HYDROLOGY DEVELOPMENT SECTION DEVELOPMENT REVIEW BOARD MEMO

DRB PROJECT NO: 1003916

Re: Santa Monica Place Tracts 1-4, Conceptual Drainage Report
Engineer's Stamp dated 12-2-2011 (D18/D054)

**Re: Broadstone Santa Monica Place
Grading and Drainage Plan
Engineer's Stamp dated 4-10-2012 (D18/D054)**

OVERFLOW WEIR AT CONCRETE STILLING BASIN @ NW CORNER

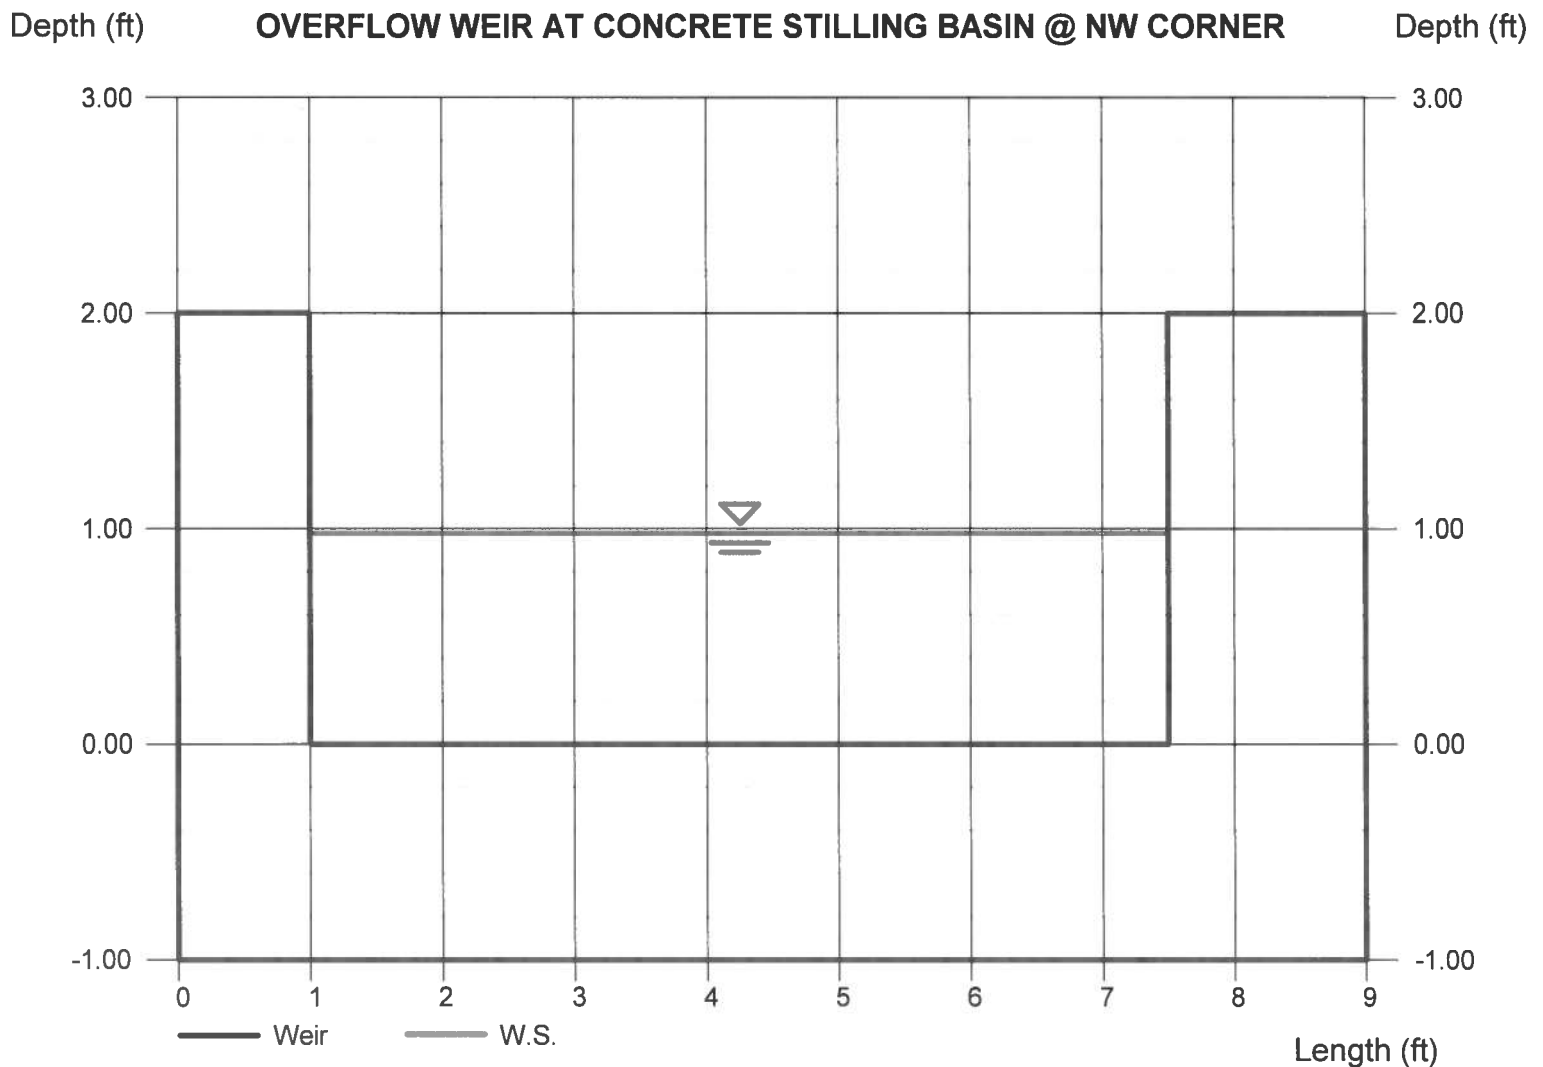
1. The intent of the storm drain outfall structure is to dissipate the velocity of the storm drain discharge and overflow it to the south paved drive over a 6.5-foot wide weir. Flow remaining in the lower 6 inches will pass to the north via the proposed 4-inch drainline. The peak flow in the 4-inch pipe is 0.5 cfs and the remaining flows of 21.0 cfs discharges via the weir. See Supplemental Calculations for weir overflow and 4-inch orifice calculations. Based on these calculations, the water surface elevation will be 63.0—one foot above the flowline elevation. The curb adjacent to the weir will be 12 inches high with transitions to the top of wall elevation of 64.5.
